**OX17 1QU**

**Applicant:** Mr James Doran

**Proposal:** Change of use of land to a mixed use for the keeping of horses (existing) and as a residential caravan site for 4no gypsy families. Each with two caravans (including no more than 4no static caravans / mobile homes) together with the laying of hardcore.

# SITE LAYOUT PLAN

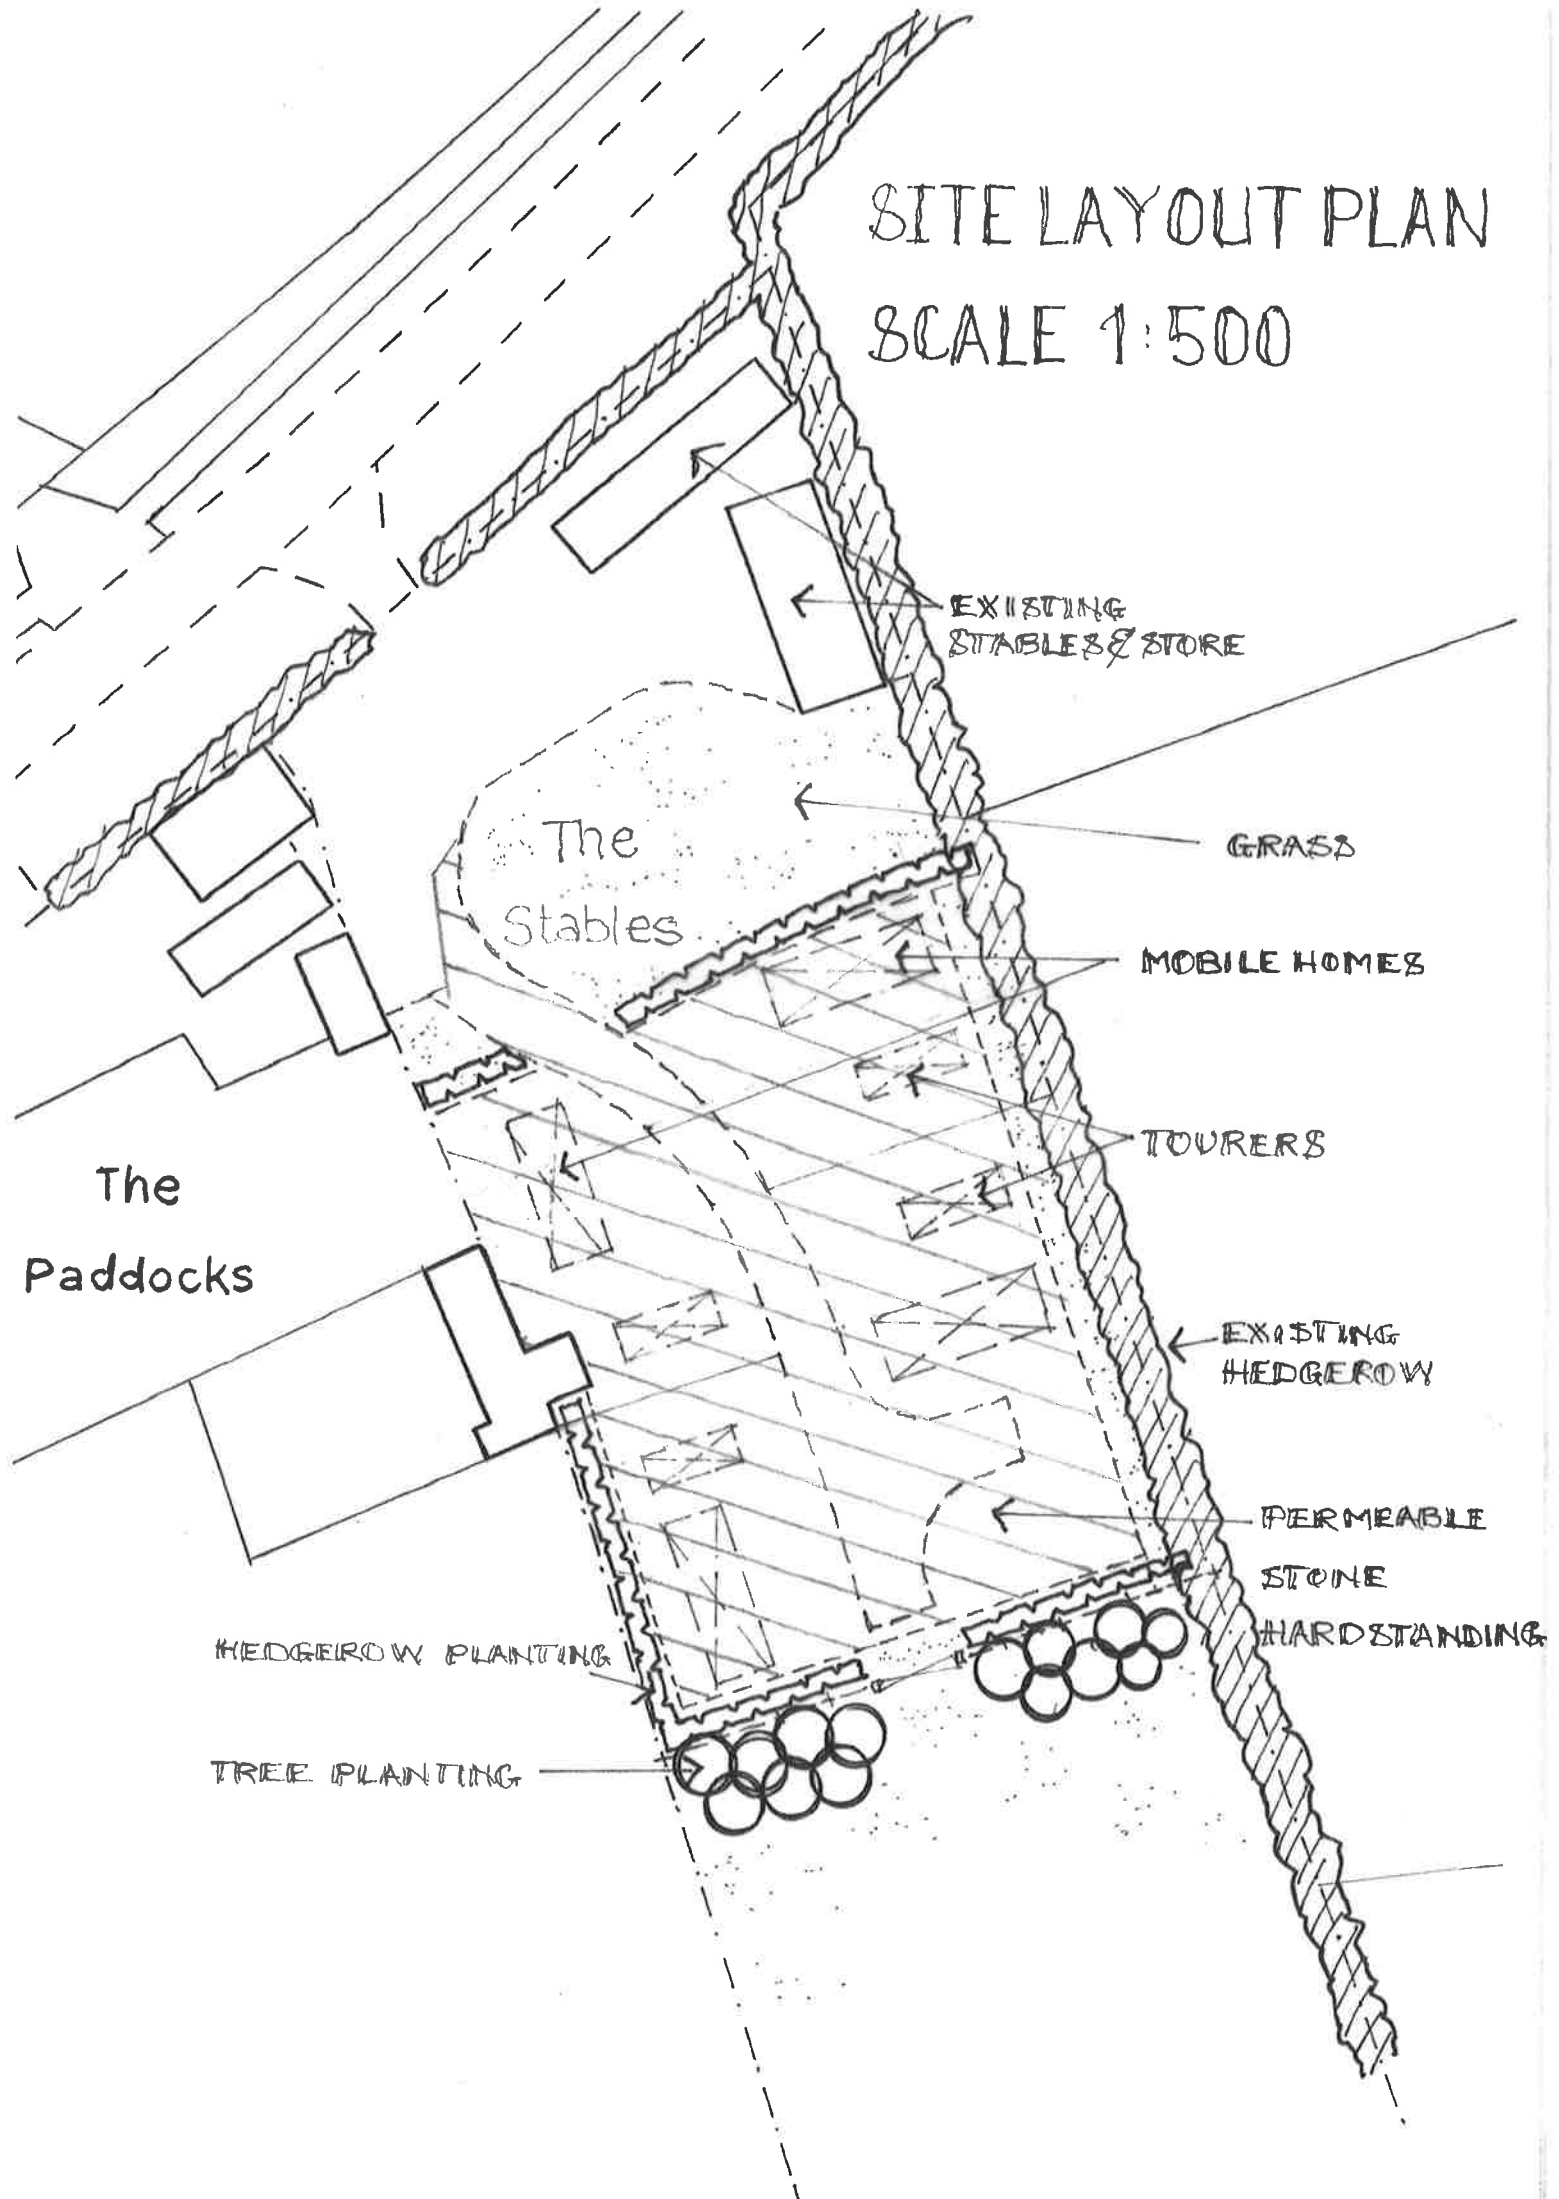
- 9.33. The applicant has failed to acknowledge the existing authorised PRow, which crosses through the site, or address the clear impacts that the proposals would have on this route and the amenity of its users.

- 9.36. No detailed information has been submitted in respect of waste and recycling or how the storage of such would be accommodated within the site. Whilst it is considered that there is sufficient space for appropriate storage to be accommodated within the site, clearly, inappropriate storage of waste and recycling would further have the potential to detrimentally impact on the visual amenities of the site and its wider rural landscape setting.

- 9.43. With regard to the layout of the proposal, the proposed pitches would be spacious and officers are of the view that these pitches are all of a sufficient size and would allow for some privacy and amenity space for each pitch and would avoid the overcrowding of the site.
